WEST SUSSEX COUNTY COUNCIL CONSULTATION

TO:	Arun District Council FAO: Amy Myer
FROM:	WSCC - Highways Authority
DATE:	18 November 2021
LOCATION:	1 Greenways Crescent Ferring BN12 5EF
SUBJECT:	FG/184/21/PL Erection of replacement dwelling and garage
DATE OF SITE VISIT:	n/a
RECOMMENDATION:	Advice
S106 CONTRIBUTION TOTAL:	n/a

Figure 7: Proposed garage

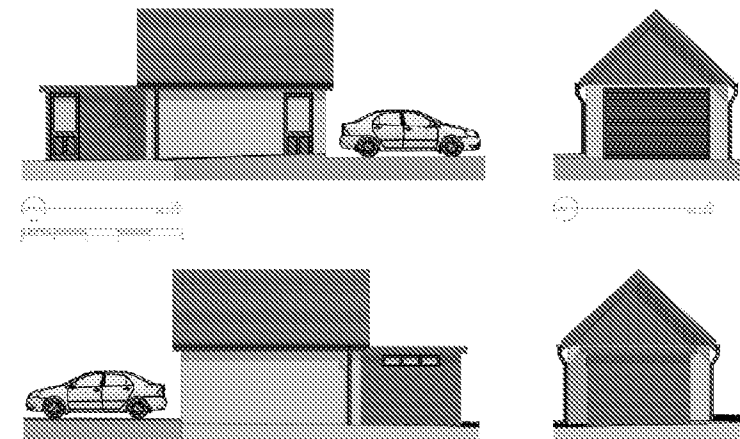
The proposed plans demonstrate that 3 parking spaces will be provided on site, this includes a single garage. The proposed floor plan drawing indicates that the garage measures 3.8 x 5m. This does not meet the minimum internal specifications of 3 x 6m for a single garage as set out in Manual for Streets (MfS). However the LHA appreciate that a smaller sized vehicle could utilise the garage as proposed and would not raise any highway safety concerns with this. In addition the proposed plans indicate that there is sufficient space on the proposed driveways to accommodate additional parking if required. The plans also demonstrate that the vehicles can turn on site and exit onto the public highway in a forward gear.
